**RE: Shoppes at Ellison (S. of La-Z-Boy)
Drainage and Grading Plan | Engineer's Stamp Date 5-23-2016 (File: A14D010E)**

Based upon the information provided in your submittal received 2-3-2016, the above referenced plan is approved for Building Permit.

RE: Shoppes at Ellison (S. of La-Z-Boy)
Drainage and Grading Plans, Revised 05/23/2016 (File: A14/D010E)

C1.1

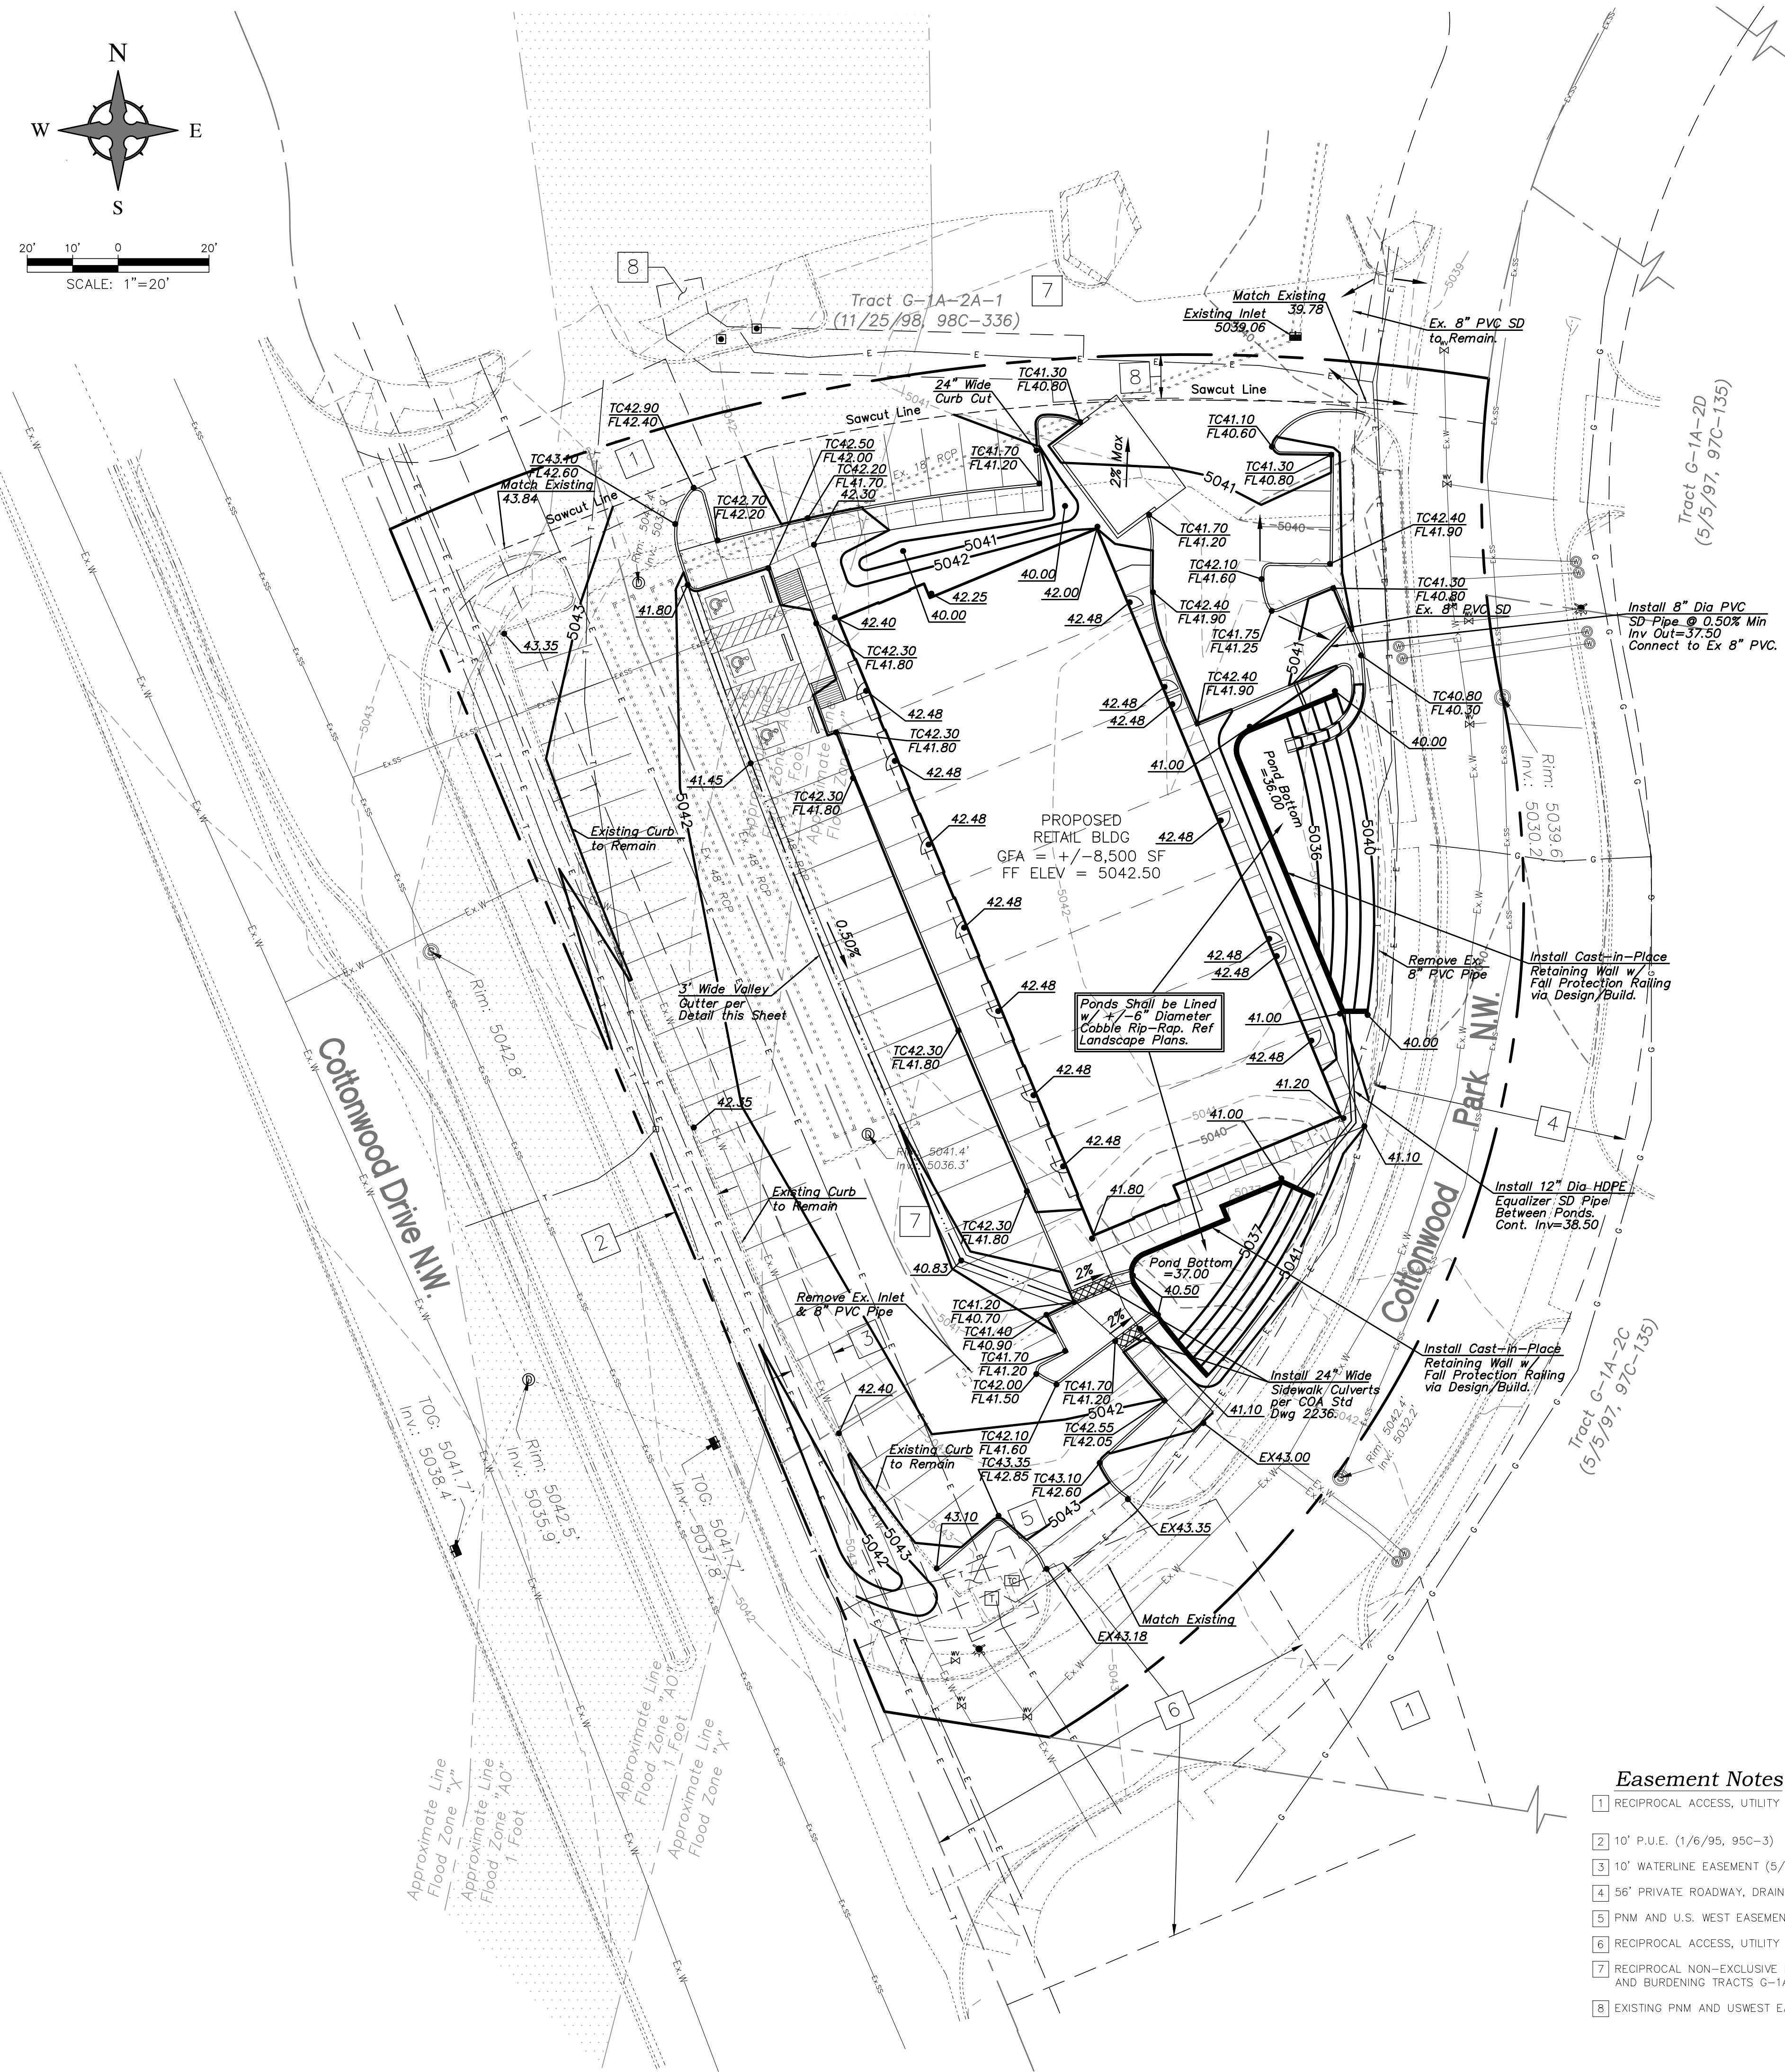
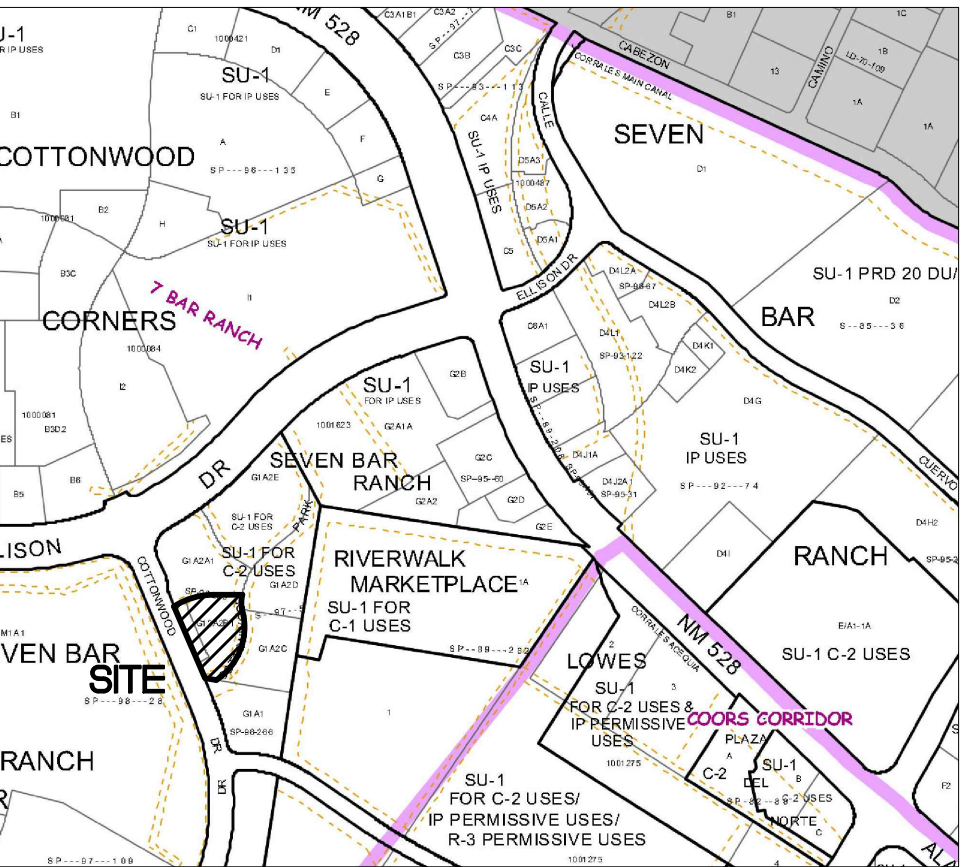
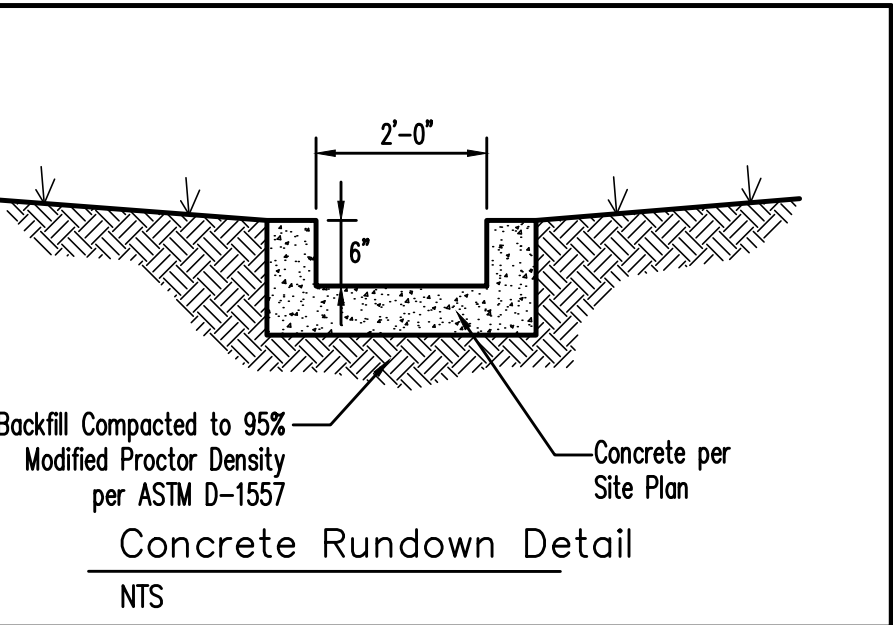
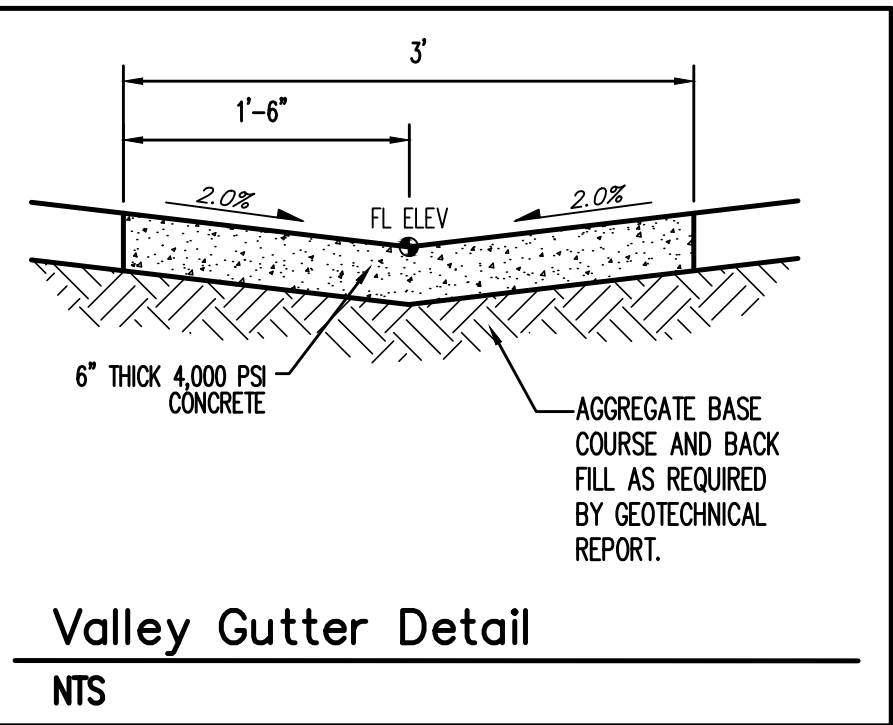
As you are aware, there is a 'ghost' floodplain across the site. Please ensure that a Floodplain Permit is filled out prior to construction, to help the City justify the elevation criteria for this project. It will be a condition for approval for Certificate of Occupancy.

1. Since the 12" pipe is an equalizing pipe, there is a single invert elevation of 5038.50 as shown on the note for the pipe on the grading plan.

2. The ponds have been sized to capture over the 100-Yr, 6-Hr storm; therefore, the ponds are sized adequate to prevent overtopping. The 8" pipe is only being installed to allow the pond to discharge quicker than just evaporation and infiltration alone. If you prefer, we can delete the proposed 8" pipe and allow any excess flows to discharge over the parkway/curb into Cottonwood Park.

3. We have added the 'Landscape Buffer Swale' detail you sent over and added notes as required.
4. We have added a detail for the Sidewalk Culvert/Wall detail as requested.

5. A set of double cleanouts have been shown on the proposed 8" pipe. The section of existing 8" pipe to remain already has double clean-outs installed per the original plans by RP Bohannon.

6. The proposed roof drains have shown and flow arrows added to the grading plan showing direction of flow. All roof drains shall drain into Pond 'C'.
7. We have added elevations on the first flush calculations table as required for Ponds 'B' and 'C'. Since the ponds are in a 'retention' condition, all flows are captured.
